Our Ref:239848
Department Ref: SSD-9827

**RE: PART LOT 4 DP 1238761
45 HONEYSUCKLE DRIVE, NEWCASTLE.**

Thank you for your letter dated 21 February 2020 providing the Departments request for additional information in relation to the above application following further assessment. Please accept this submission as our formal response to the matters raised.

JUNE 21 - shadow casting extent
11 AM

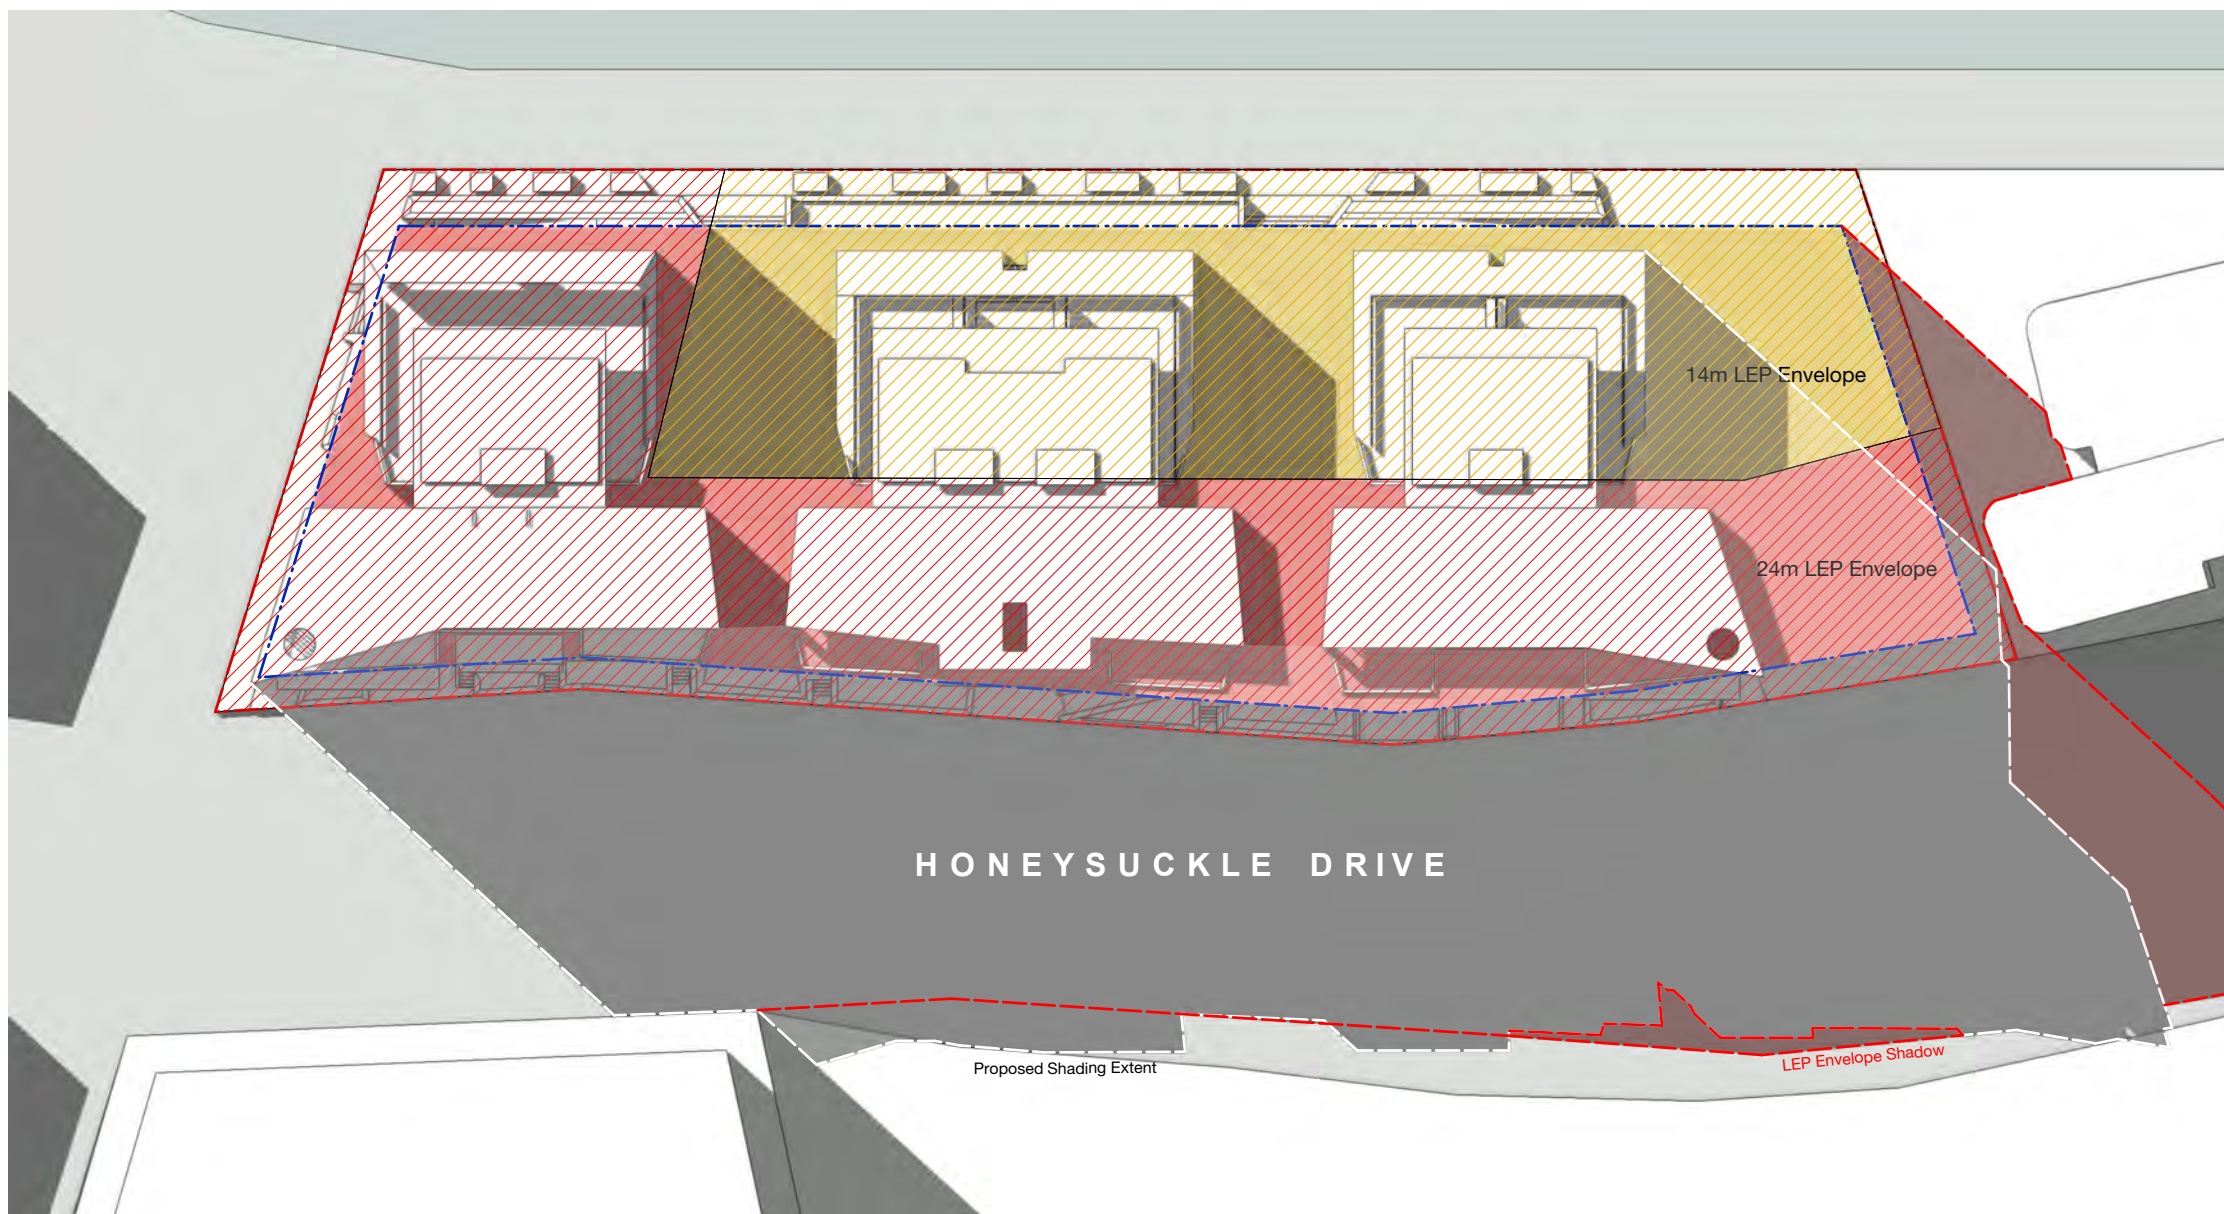
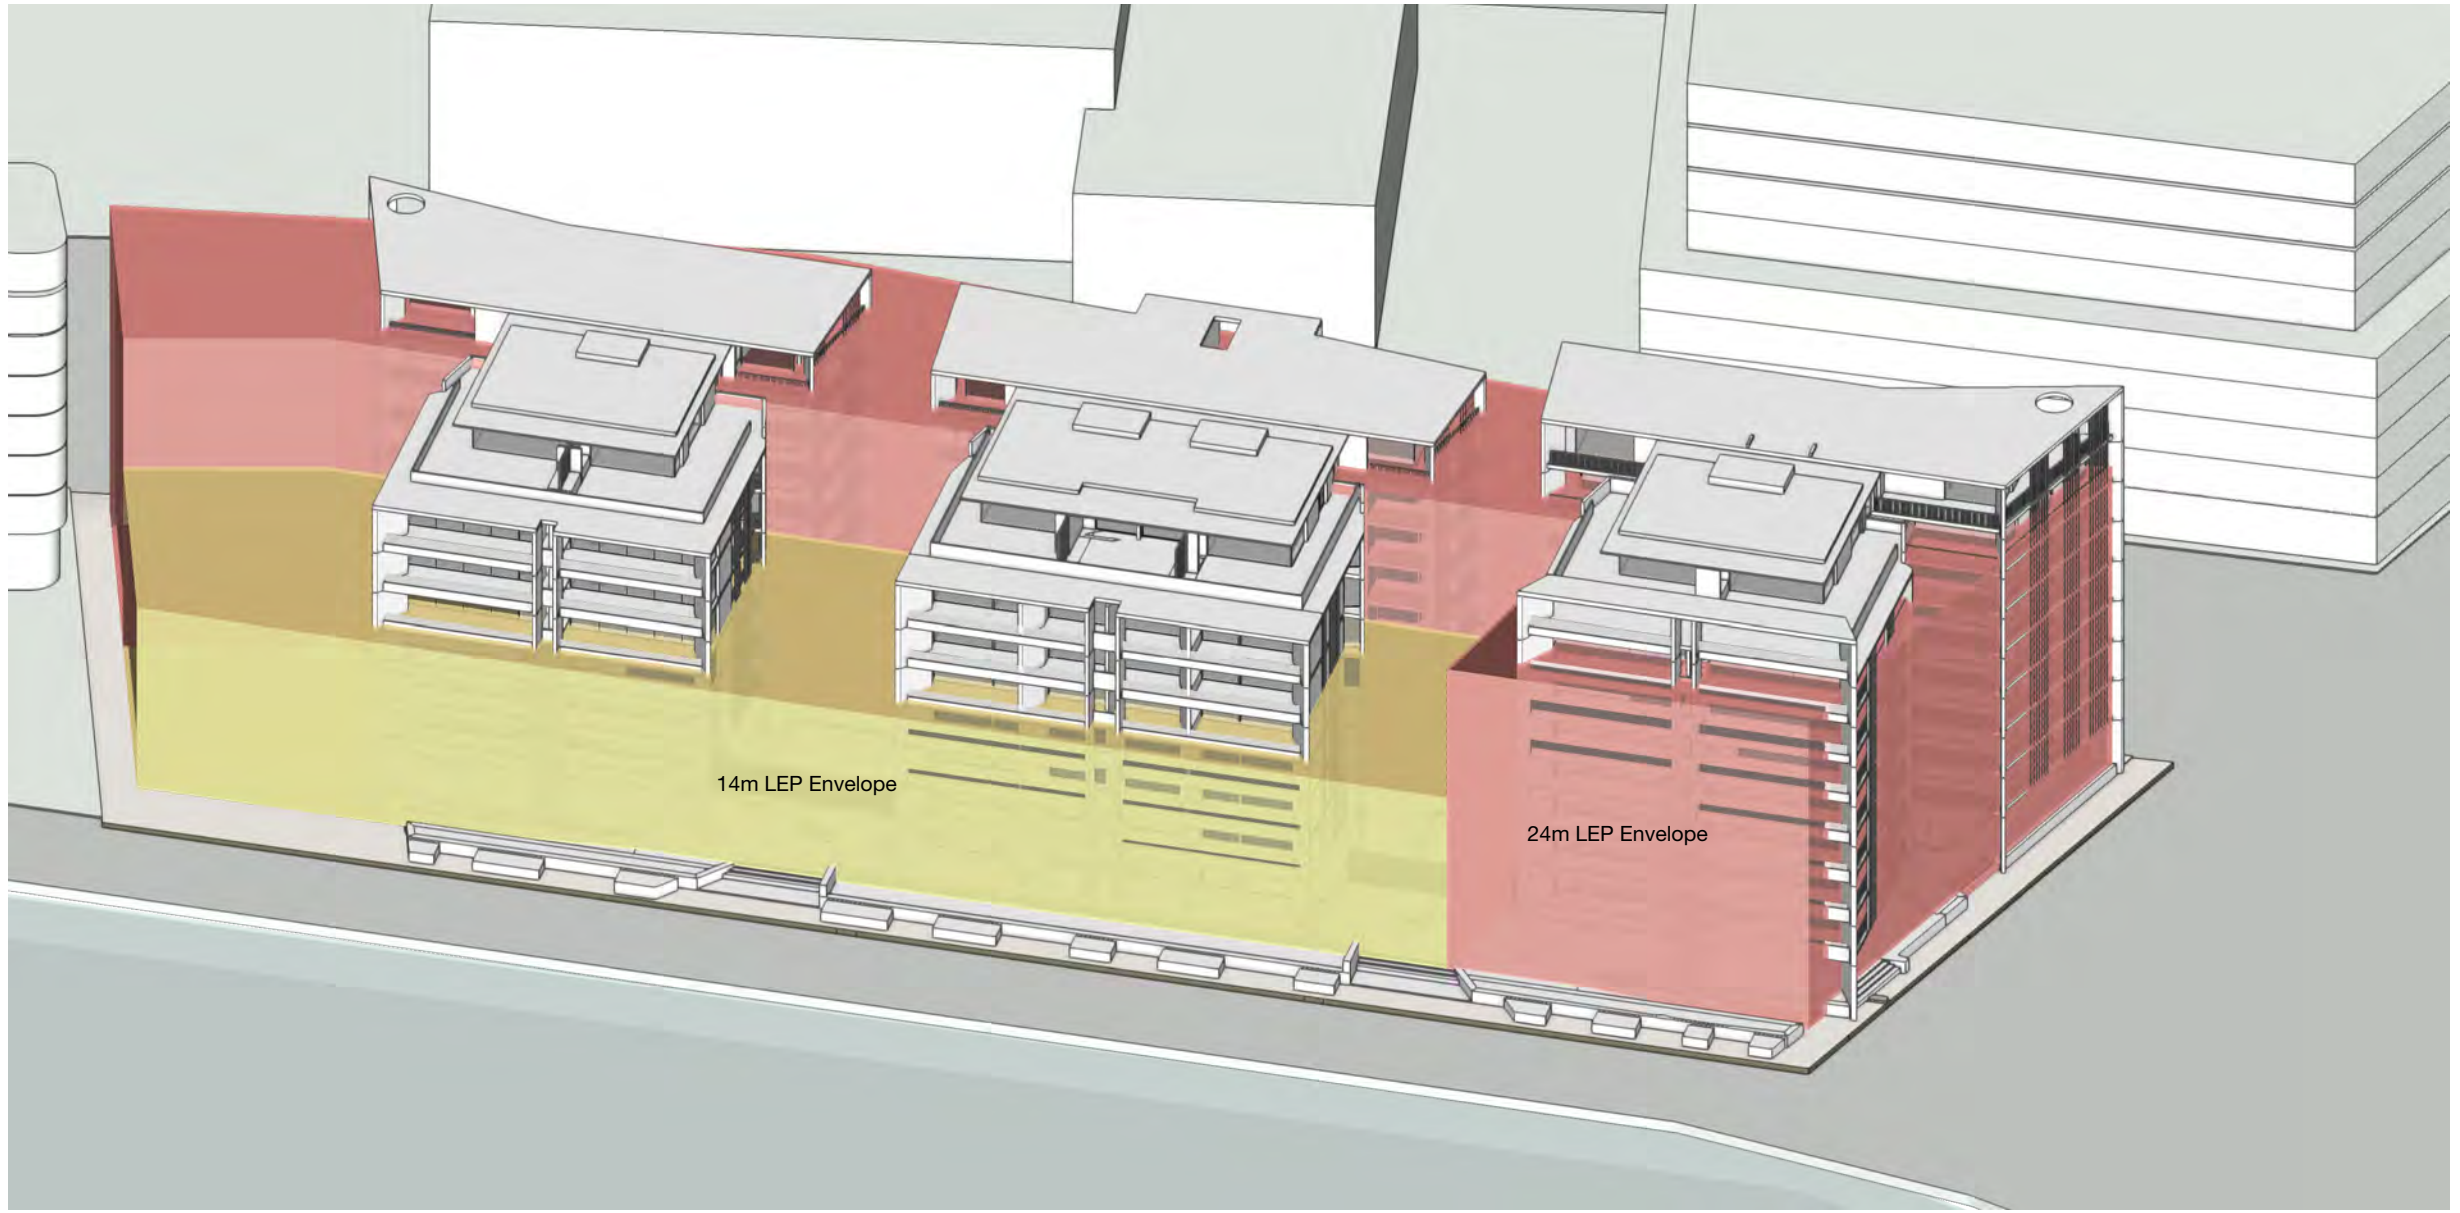
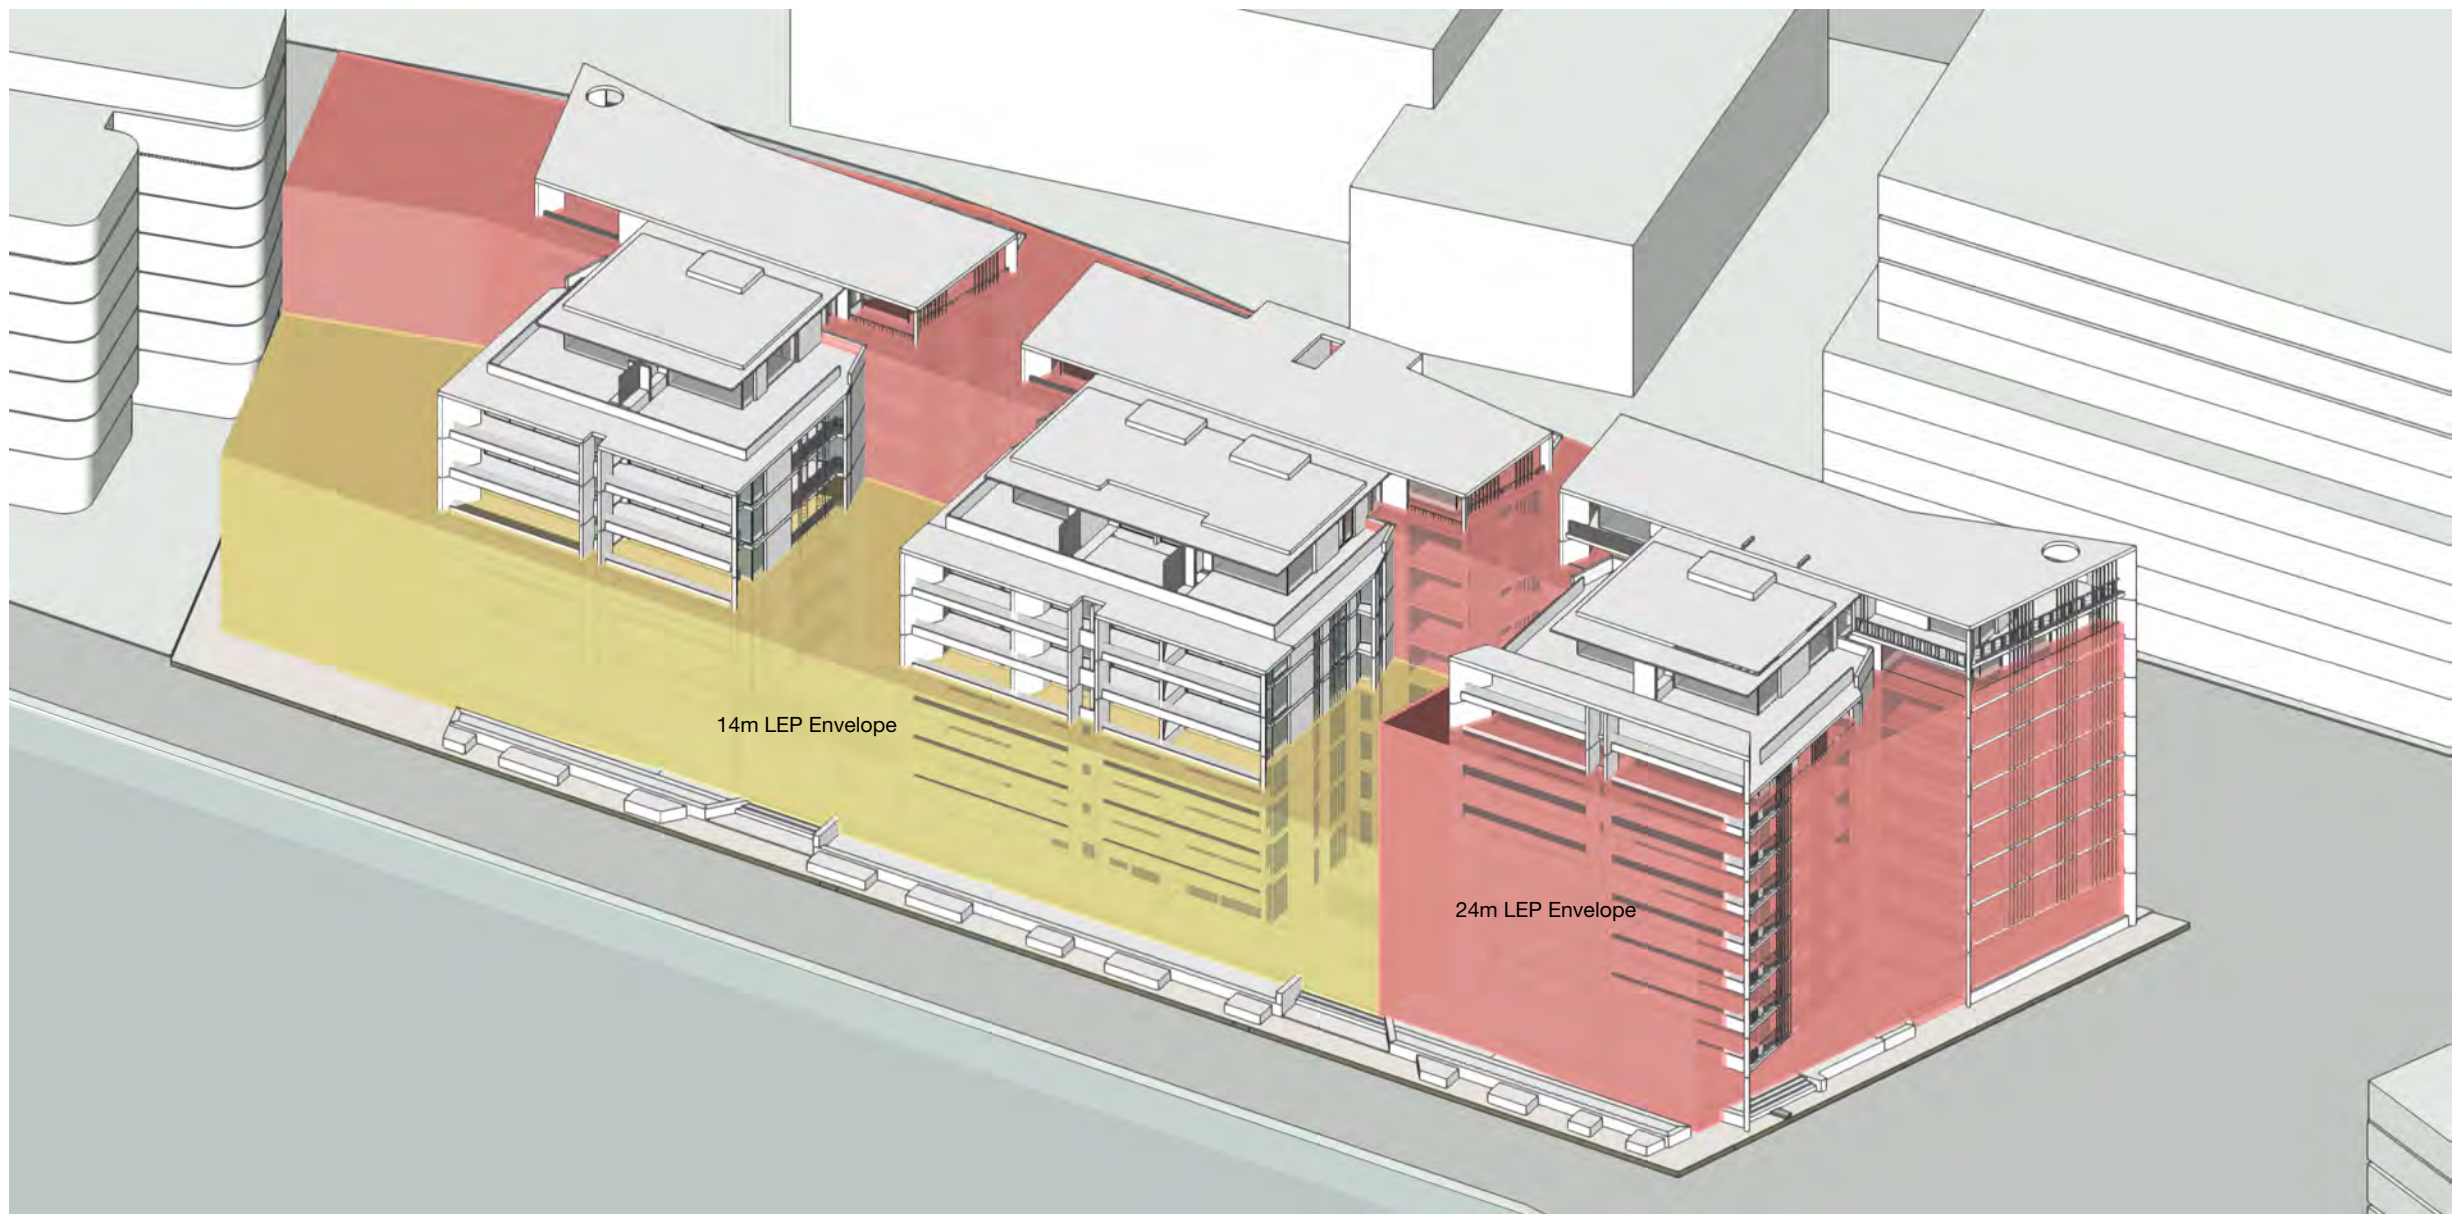
Provide an assessment of view loss impacts, using Tenacity Principles, to the residential apartments and hotel rooms of the approved development at 42 Honeysuckle Drive. The assessment should consider the current proposal as well as an LEP compliant scheme.

A typical built outcome on 45 Honeysuckle Drive would be one assumed to comply with the relevant planning provisions. In this regard, it is considered that a compliant development outcome would see the entire footprint of the site developed up the maximum height would have a greater impact on views from 42 Honeysuckle Drive than what is currently proposed.

However, because the proposed development footprint has been reduced and because a more slender built form with separation between the three (3) buildings the retained views from 42 Honeysuckle Drive are improved. Views from 42 Honeysuckle Drive will be available through the site and via the available space along the Cottage Creek corridor as shown on the below photomontage, which outlines a compliant scheme (in block form) and the proposed development.
